Application for a non-material amendment following a grant of planning permission.
Town and Country Planning Act 1990

PROPOSED SINGLE STOREY EXTENSION TO DWELLING

Provision of 1.5 x 0.9m window at ground floor level to north west elevation

PROPOSED GROUND FLOOR PLAN

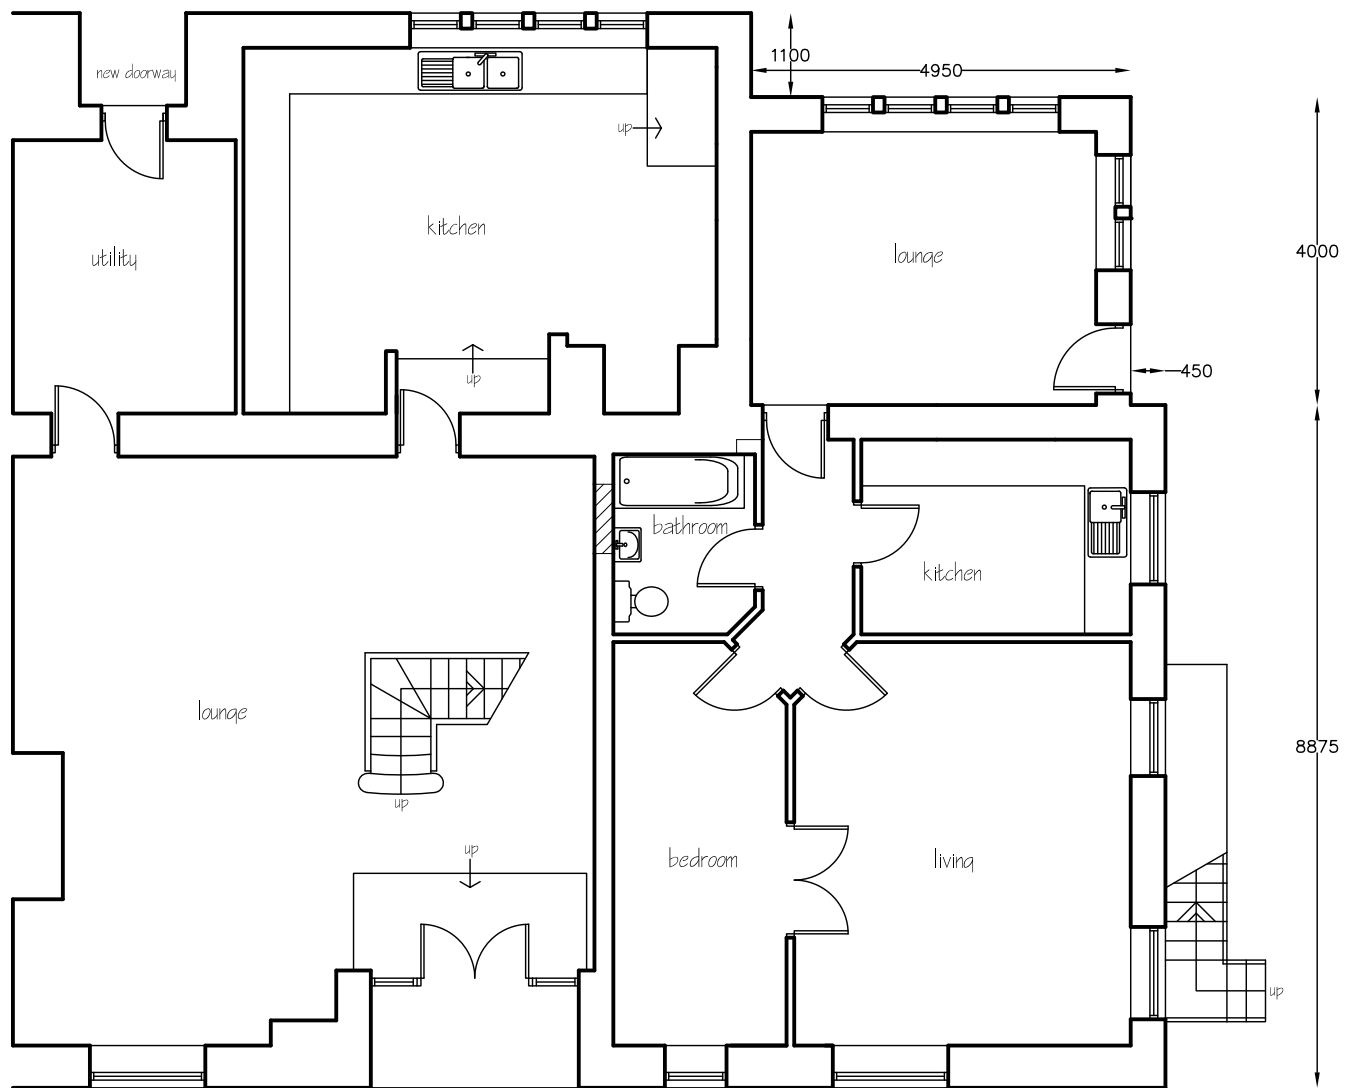
To improve natural daylight into the lounge area.
